Acceptance of Applications Checklist

Heckington Fen Solar Project Section 55 Acceptance of Applications Checklist

DATE	SCALE	SHEET	REVISION
24/01/2023	1:2,500@A1	7	.

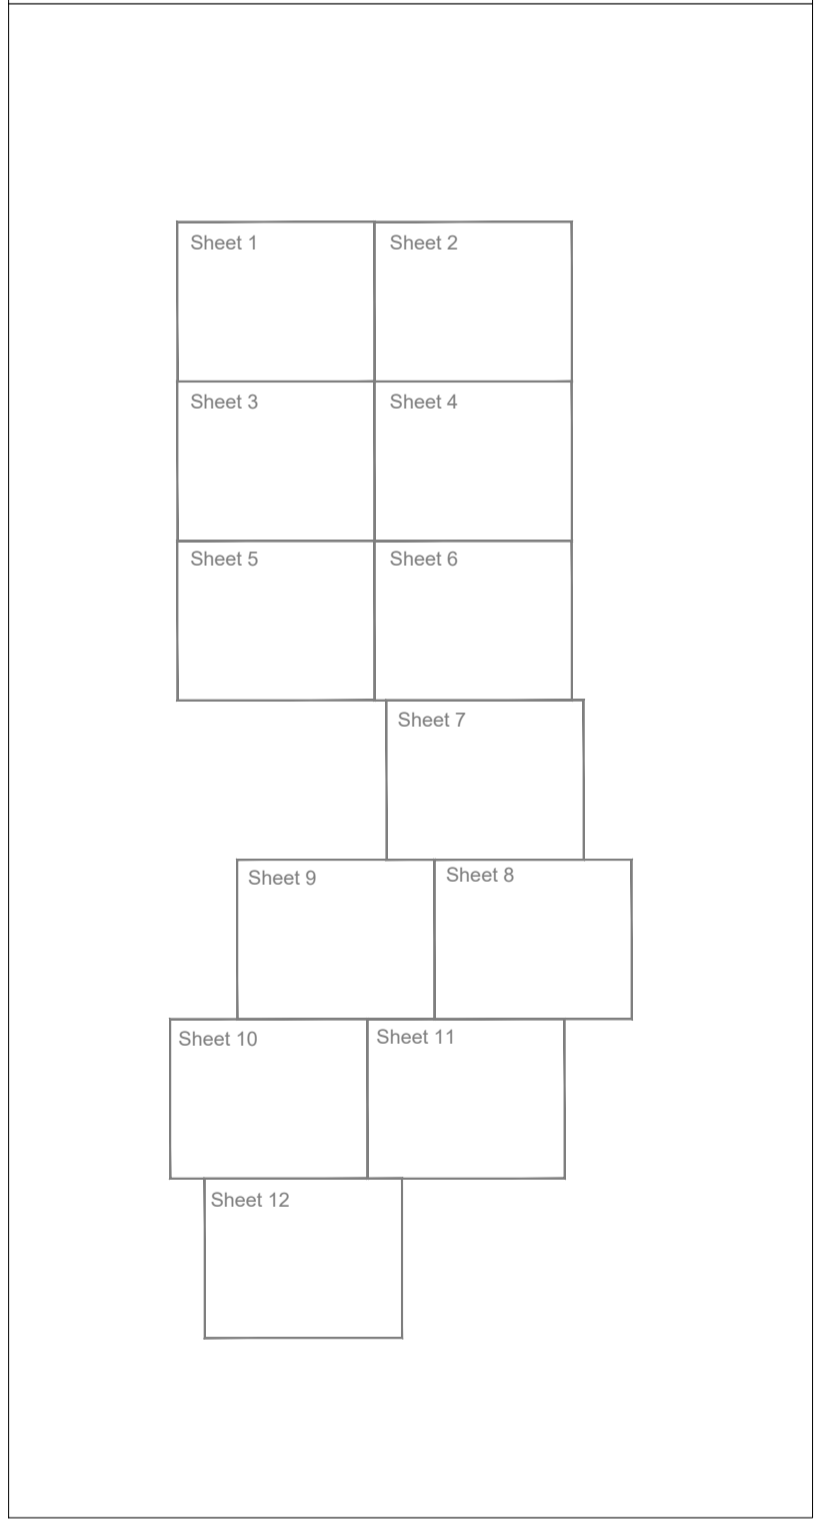
- In Schedule 4 of the draft DCO ‘Royalty Lane’ is named, but this is missing from Sheet 7.
- In Schedule 4 of the draft DCO ‘Timms Drove’ is named, but this is missing from Sheet 9.
- On the maps and legend ‘Temporary means of access to works’ is coloured purple however schedule 7 of the draft DCO describes this as being coloured blue. The applicant should update this inconsistency to provide clarity.
- On sheet 7 identifiers CR/B and CR/D appear to be slightly off from where they need to be located.
